TOWN AND COUNTRY PLANNING ACT 1990

FULL

Reference:	H09-0011-26	Date of Decision:	11th March 2026
Applicant:	Mr & Mrs J Pateman Lowlands Hurn Bank Holbeach Hurn Spalding PE12 8JG		
Location:	Lowlands Hurn Bank Holbeach Hurn Spalding		
Description:	Proposed Domestic Garage

Job Ref: 4442-25 Drawing No: O1B

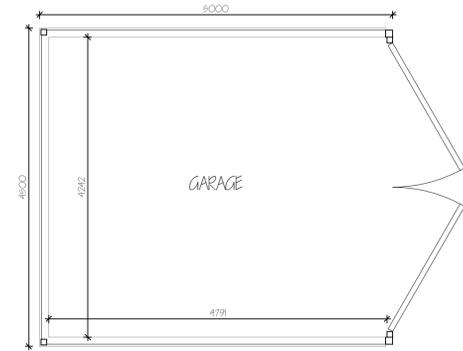
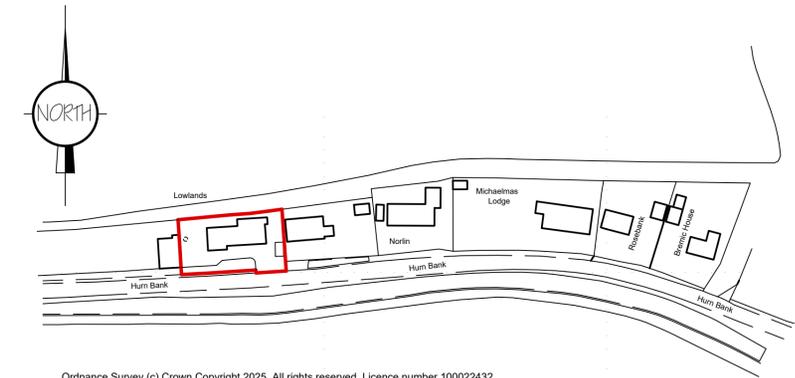
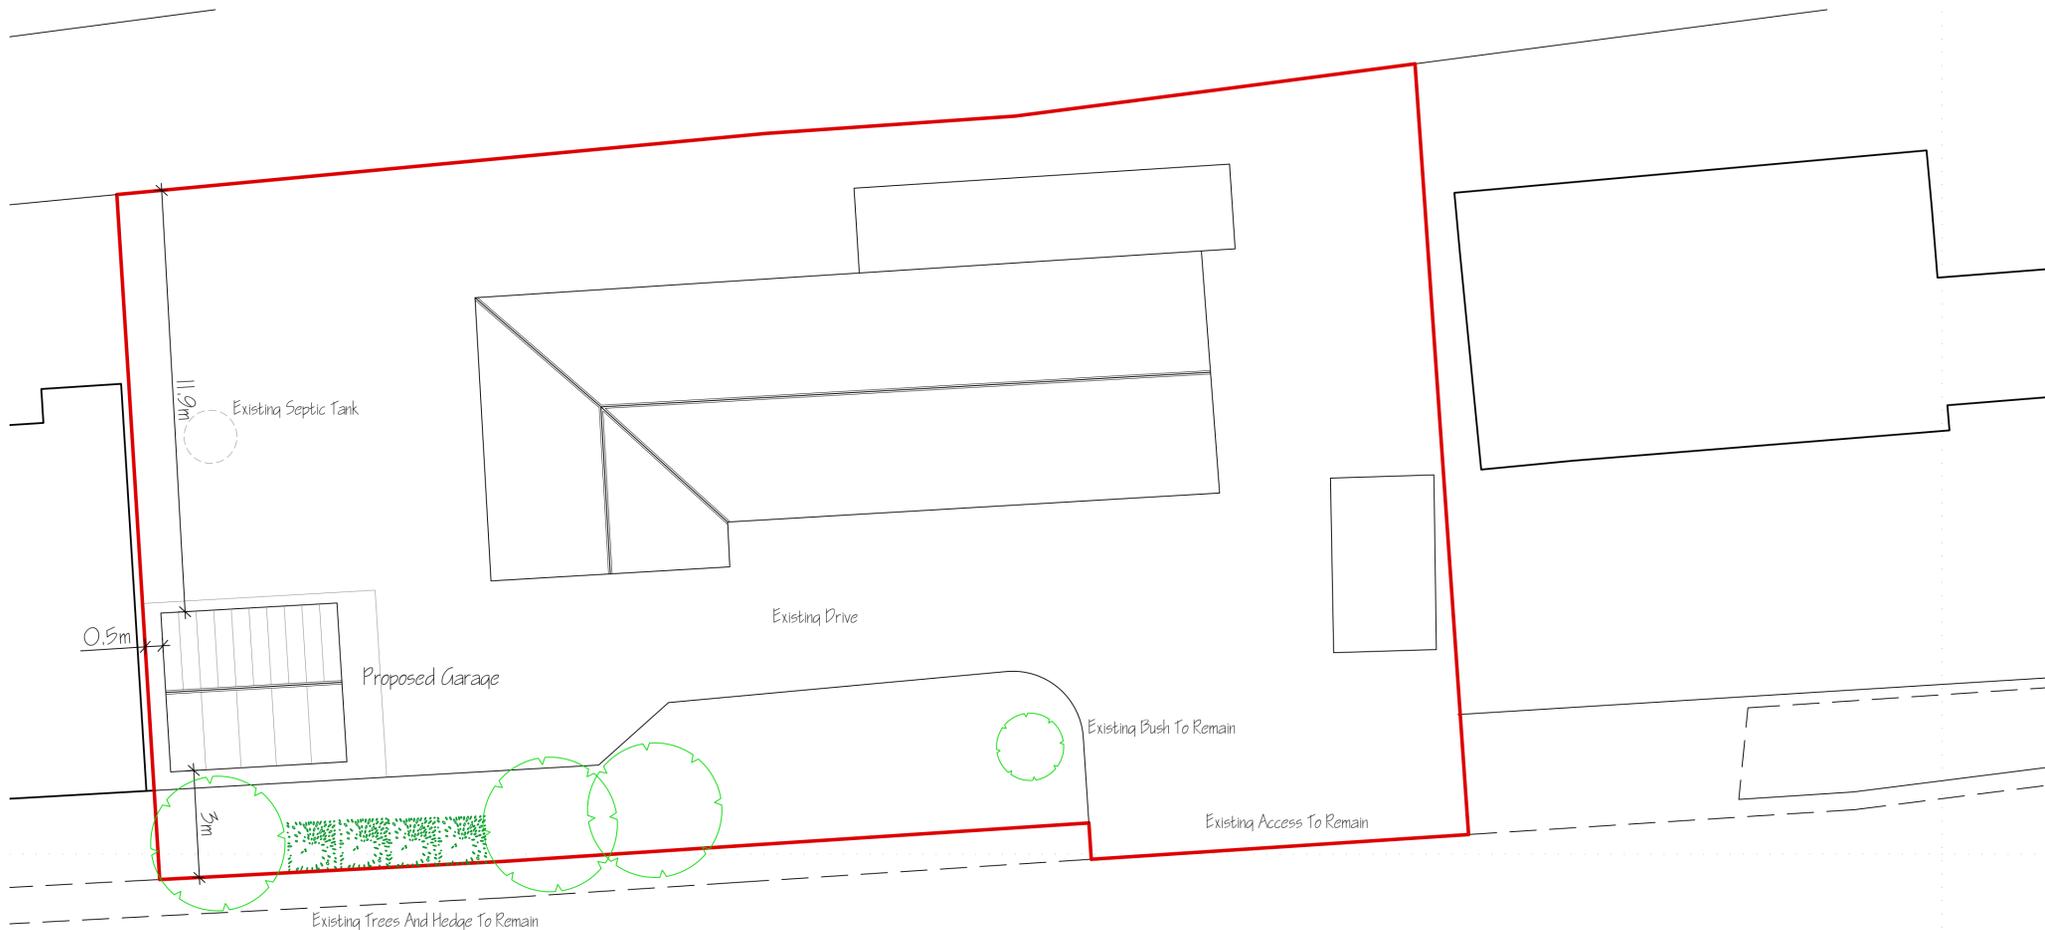
- 1 Due to the proposed siting and appearance of the garage, the proposed development would be out of keeping with the character of the surrounding area. The proposed garage building would be an incongruous and harmful feature within the street scene, resulting in an unacceptable impact on the character and appearance of the area.

As such, the proposed development conflicts with Policies 2 and 3 of the South East Lincolnshire Local Plan (2019), which seek to ensure that proposals create distinctive places that are in keeping with the area. The proposed development also conflicts with Paragraph 135 of the National Planning Policy Framework (December 2024), which seeks to maintain and protect the prevailing character and setting of areas, together with the importance of securing well-designed, attractive and healthy places.
